From: Carol Reynolds
Sent: 27 August 2019 09:39
To: Aarti O'Leary <[REDACTED]>
Cc: Anita Gardner <Anita.Gardner@arun.gov.uk>
Subject: RE: Application Ref: LU/164/19/PL - 5 Arundel Road, Littlehampton

Environmental Health: Noise

Environmental Health:

'CHANGE OF USE' PLANS

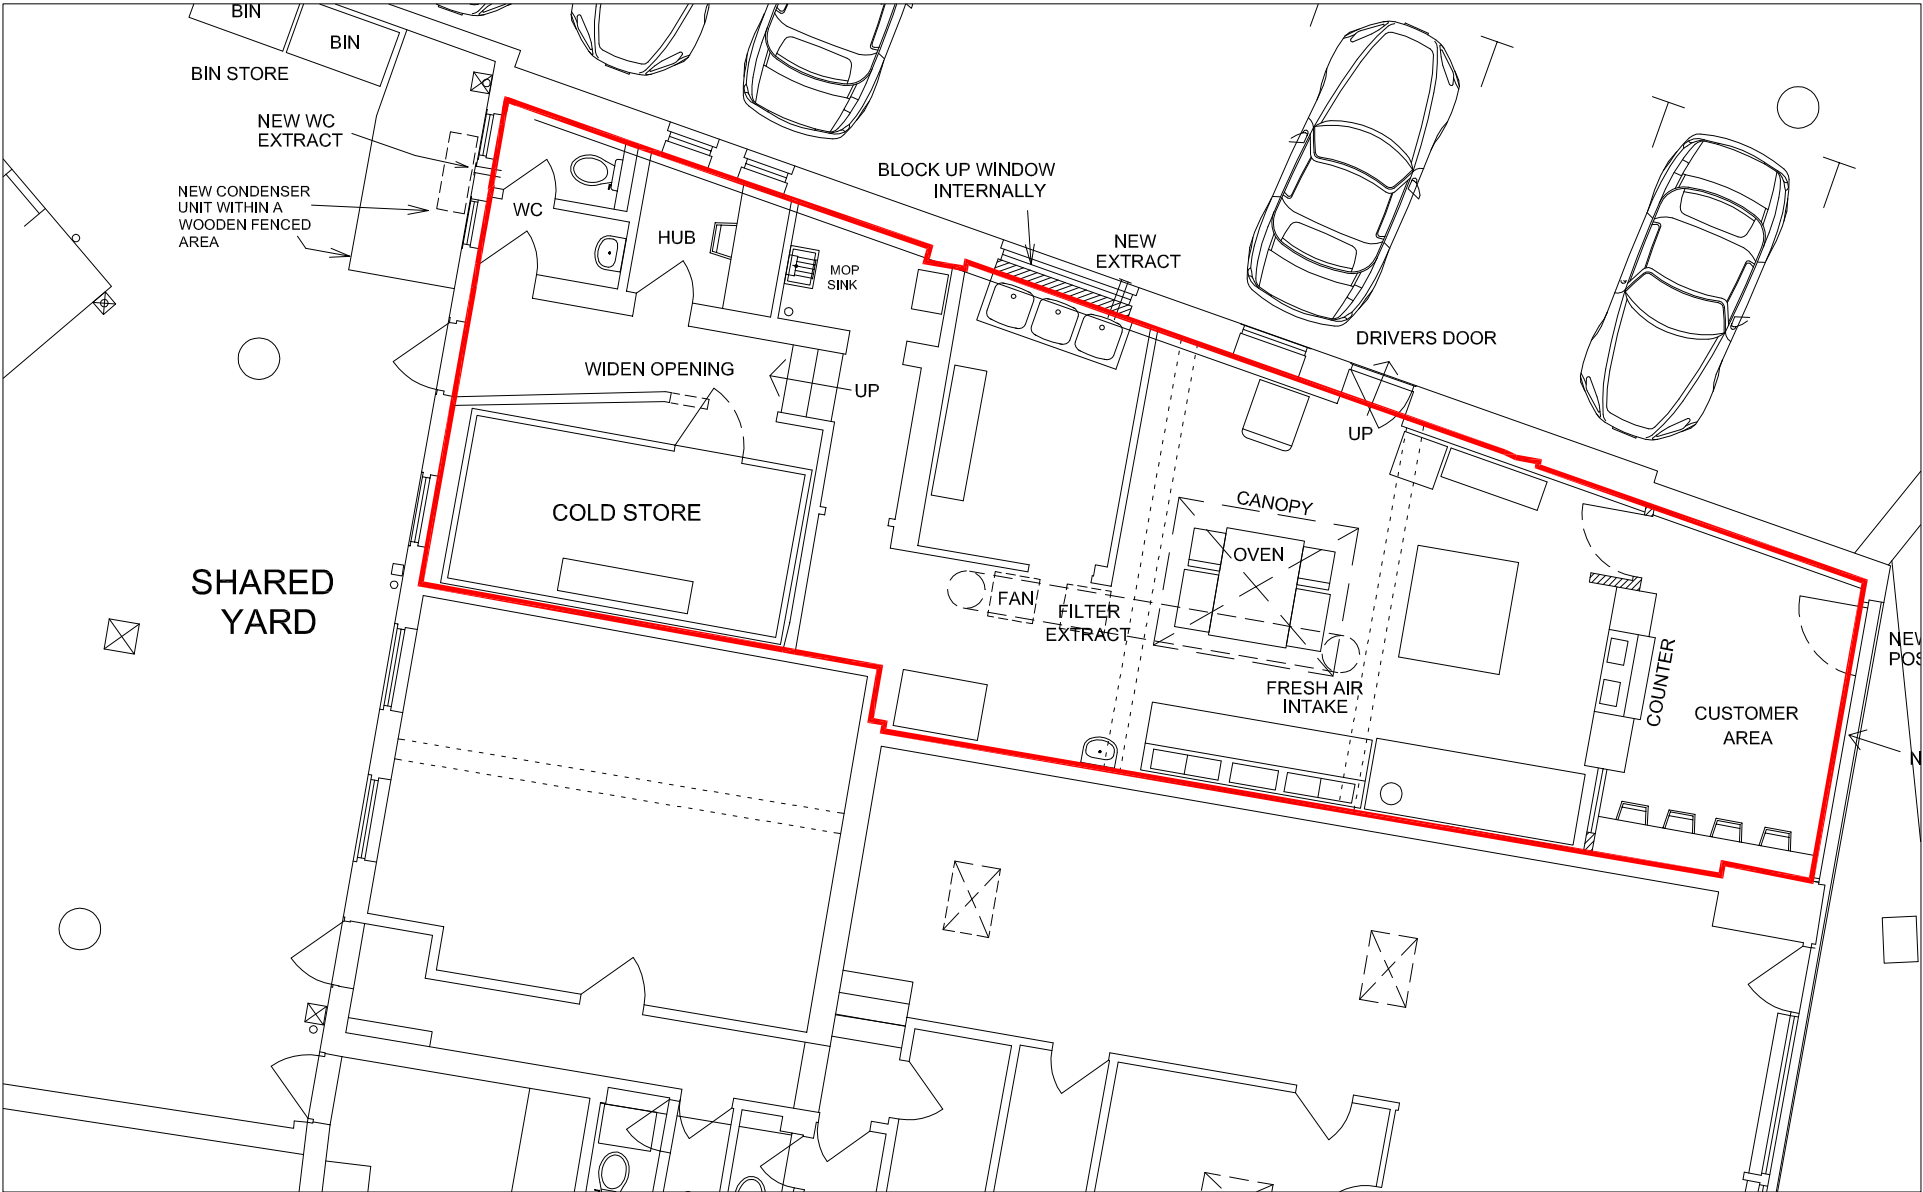
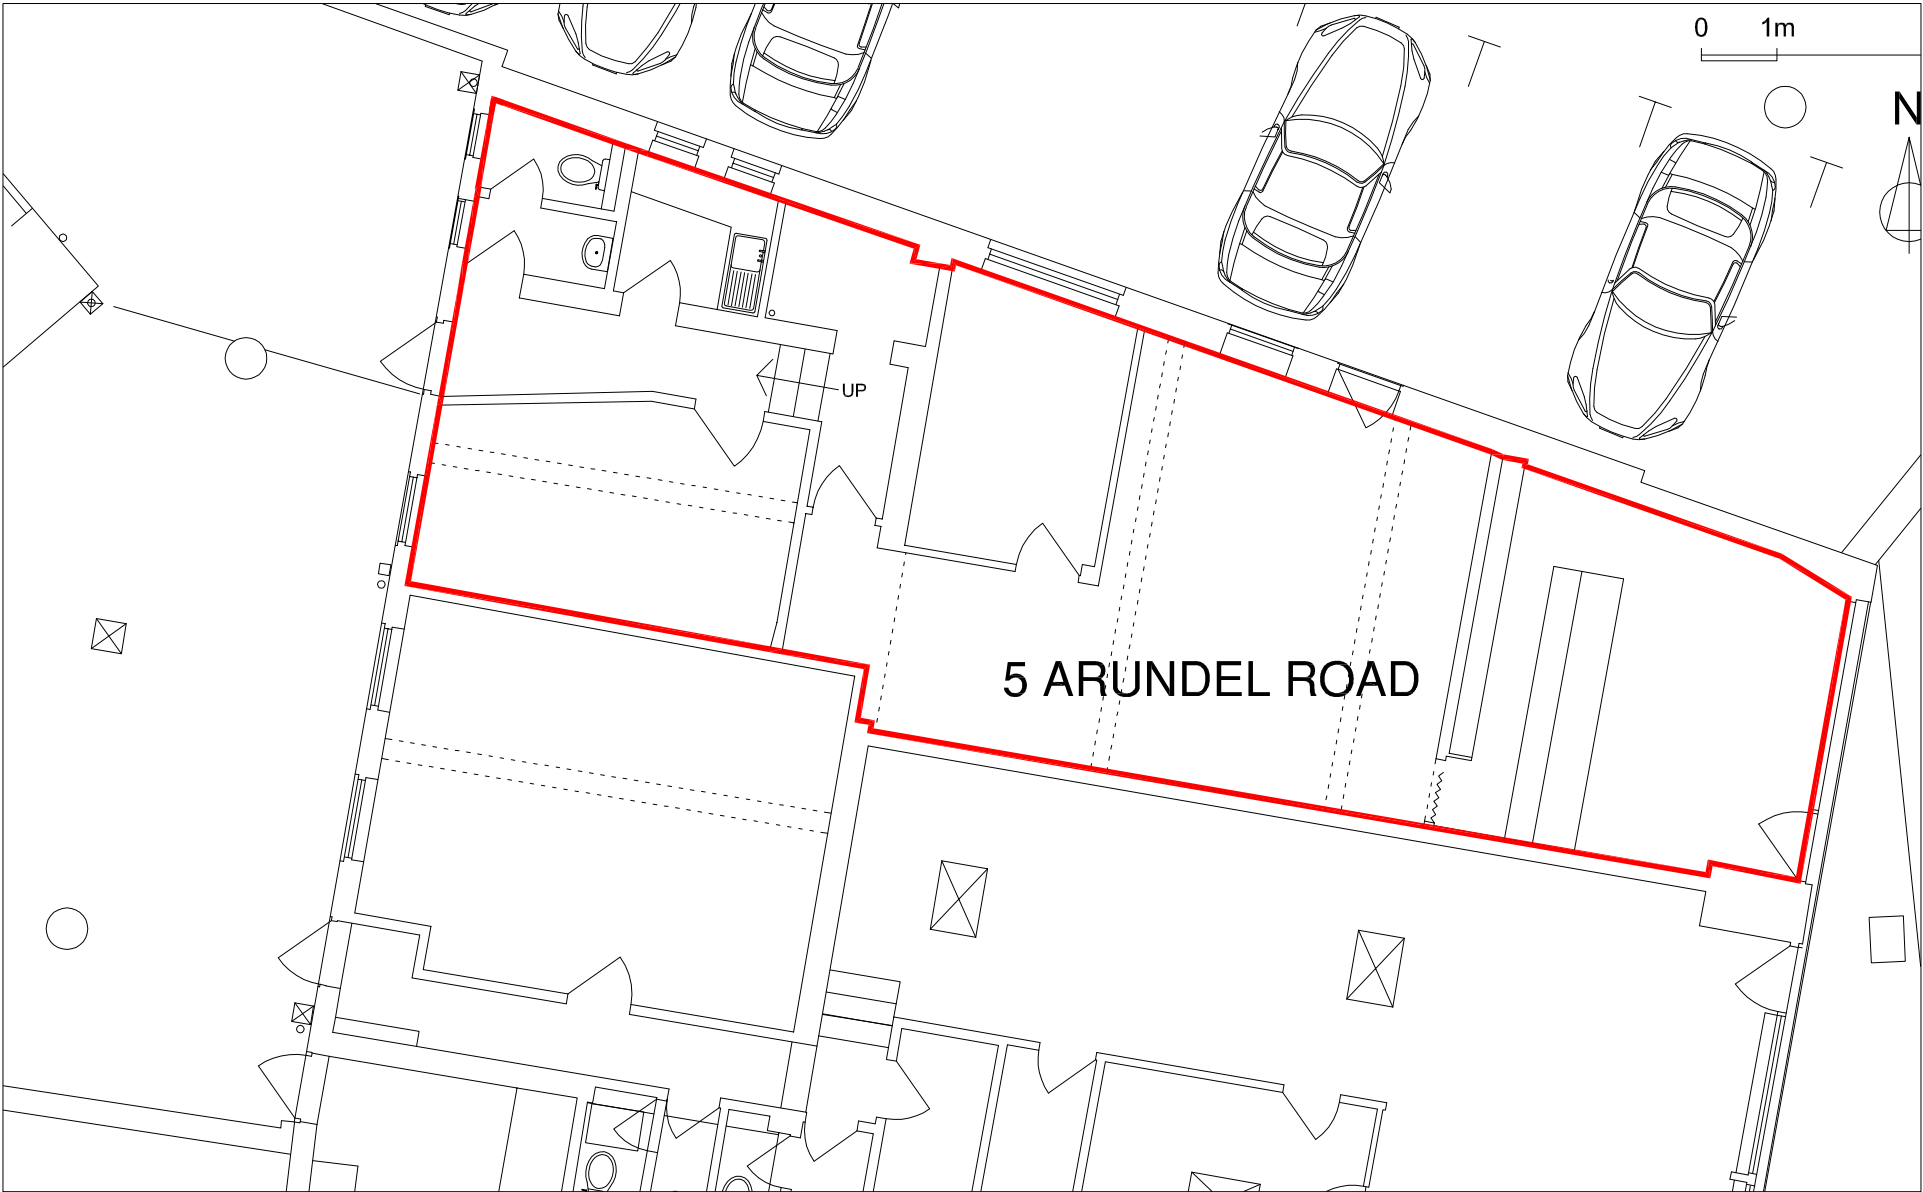
Please note that I am still not satisfied that the submitted internal layout is suitable in this case.

Informative: I await the applicant's response to my previous comment re kitchen layout and Wyg Odour Assessment, June 2019.

I would also concur that change to the internal layout of this food premises is unlikely to affect odour or noise output insofar as plant, equipment and mitigation measures already agreed are applied.

With regard to internal layout, our technical team has reviewed the plans and advised that alterations to the internal layout would not affect the odour outputs of the proposed development.

PROPOSED ELEVATIONS

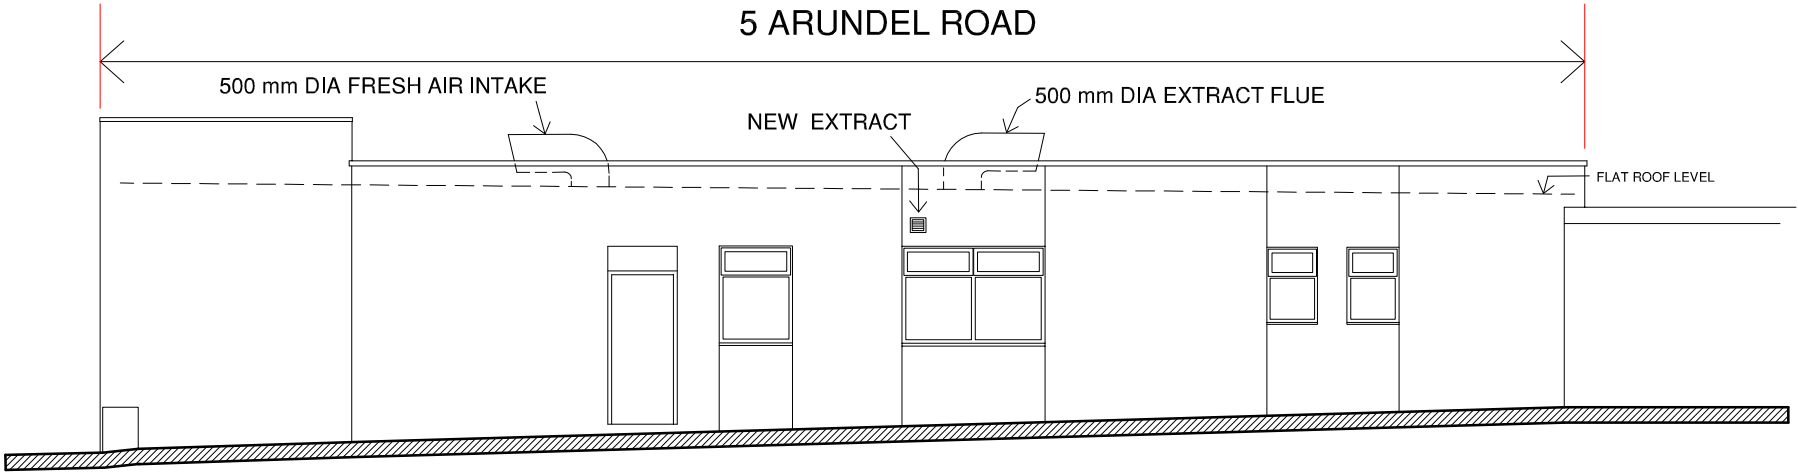
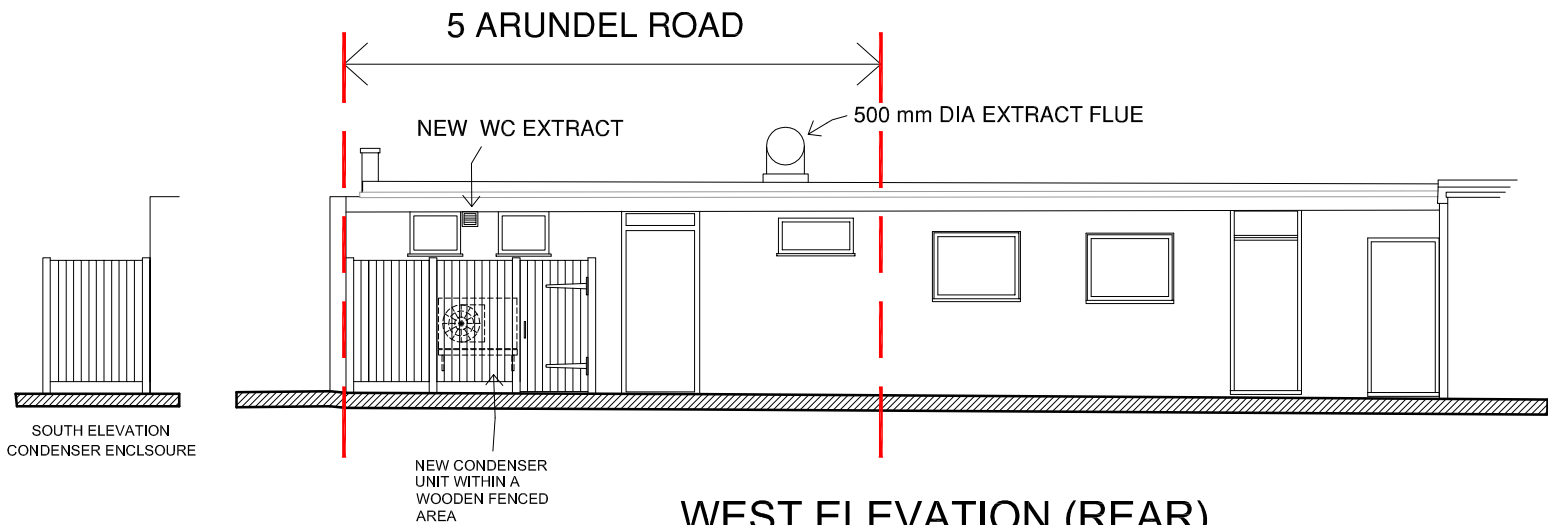
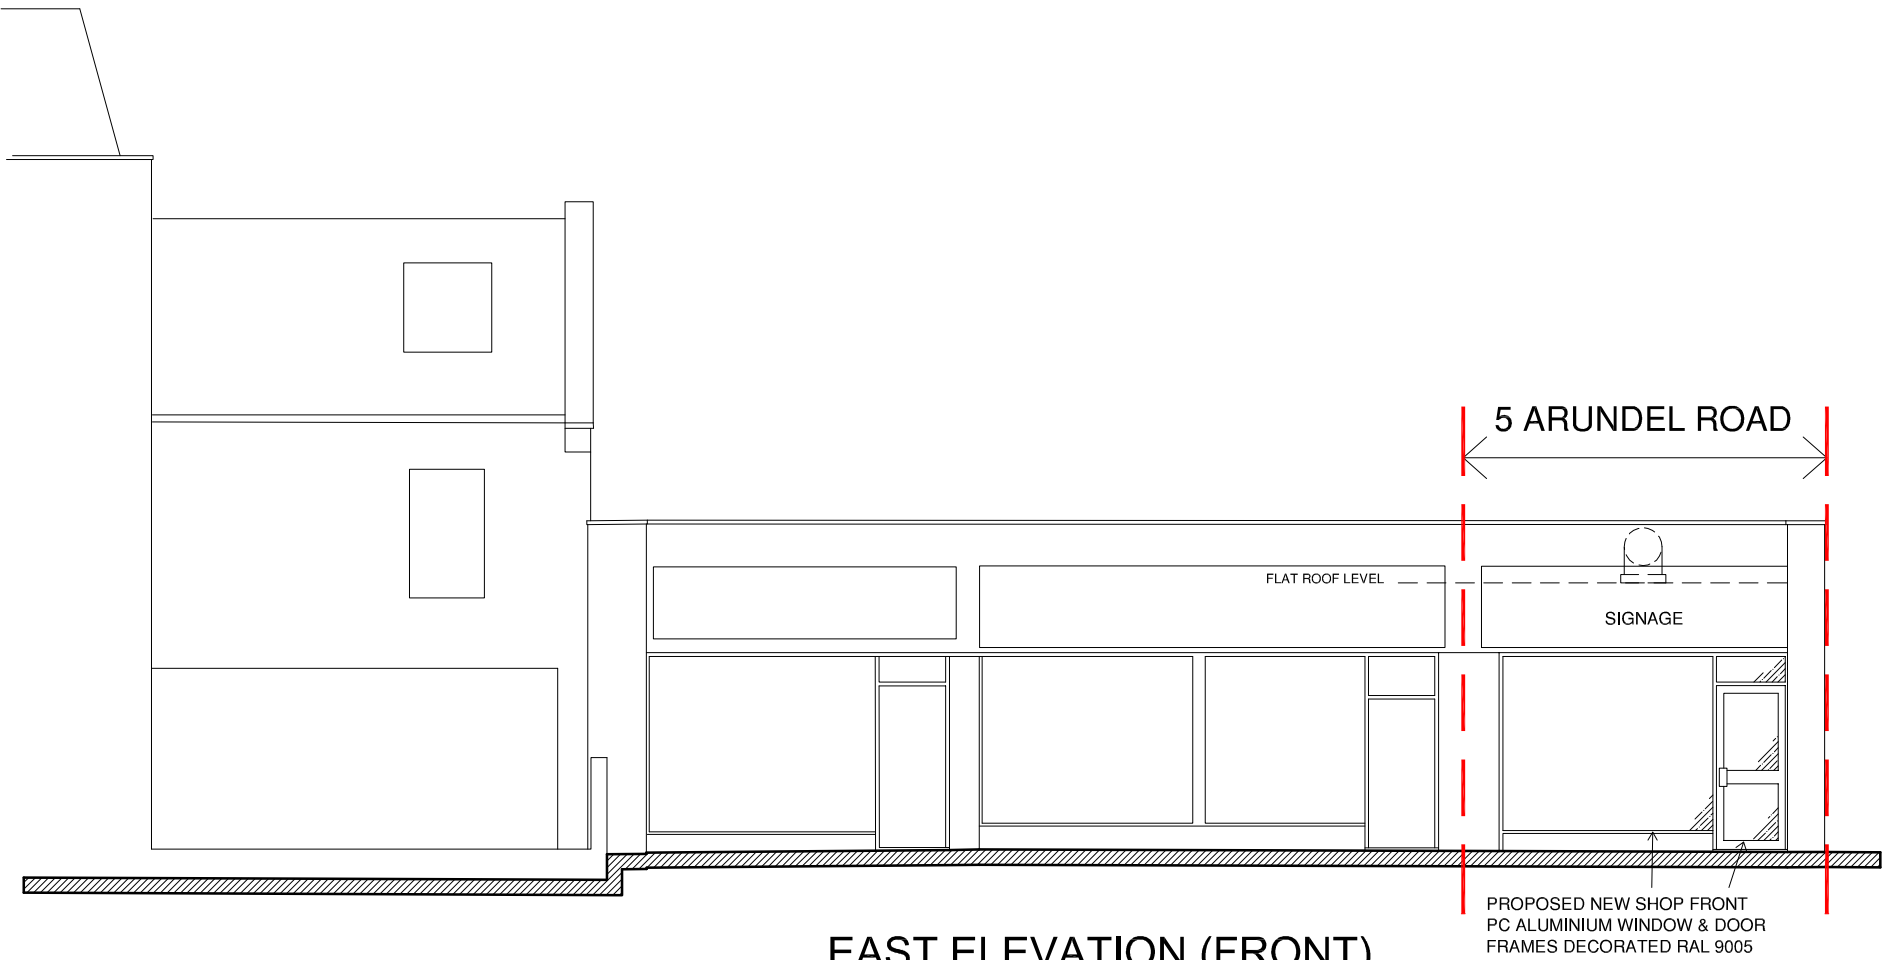
Unfortunately this report only considers noise from the condenser unit to the walk in chiller, whilst excluding other new noise sources particularly in respect of noise from the air intake and exit flue to the flat roof of this single storey building above the kitchen odour abatement system, but also extract ventilation to the kitchen sinks. Please would you request that the applicant also provides proper assessment of these areas, together with detail of any further mitigation measures that may be necessary

The proposed flue will discharge to the roof of this single storey business where it is surrounded by higher levels domestic residences. For this reason then I would dispute a dispersion Score of '10 – Moderate' instead applying the Rating '20 – Very poor,' particularly since this faces sensitive rooms of that home to the immediate north of the development. I would also Rate the size of this kitchen as 'Medium – 5 rather than Small – 1' and the type of cooking as '4 – Medium.' I agree with the Rating of 10 for the proximity of receptors, which leads me to the overall Odour Risk Assessment of 37 and the need for a 'Very High' level of odour control. Alongside baffle filters detailed then specification to be given for the type of prefilter to be provided as well as clarification as

to a 0.4 second retention time through the activated carbon filters.

"Prior to first use of the premises as a hot food takeaway (Class A5), details of the means of odour control required to achieve a 0.4 second retention time through the activated carbon filters to be submitted for approval by the Local Planning Authority. These details shall include the specification for the type of prefilter to be provided."

This includes an assessment of noise arising from the roof mounted air intake and extract flue, the extract ventilation to the kitchen sinks, the number of customers collected orders from the site, and the different vehicle types used for delivering orders to customers.
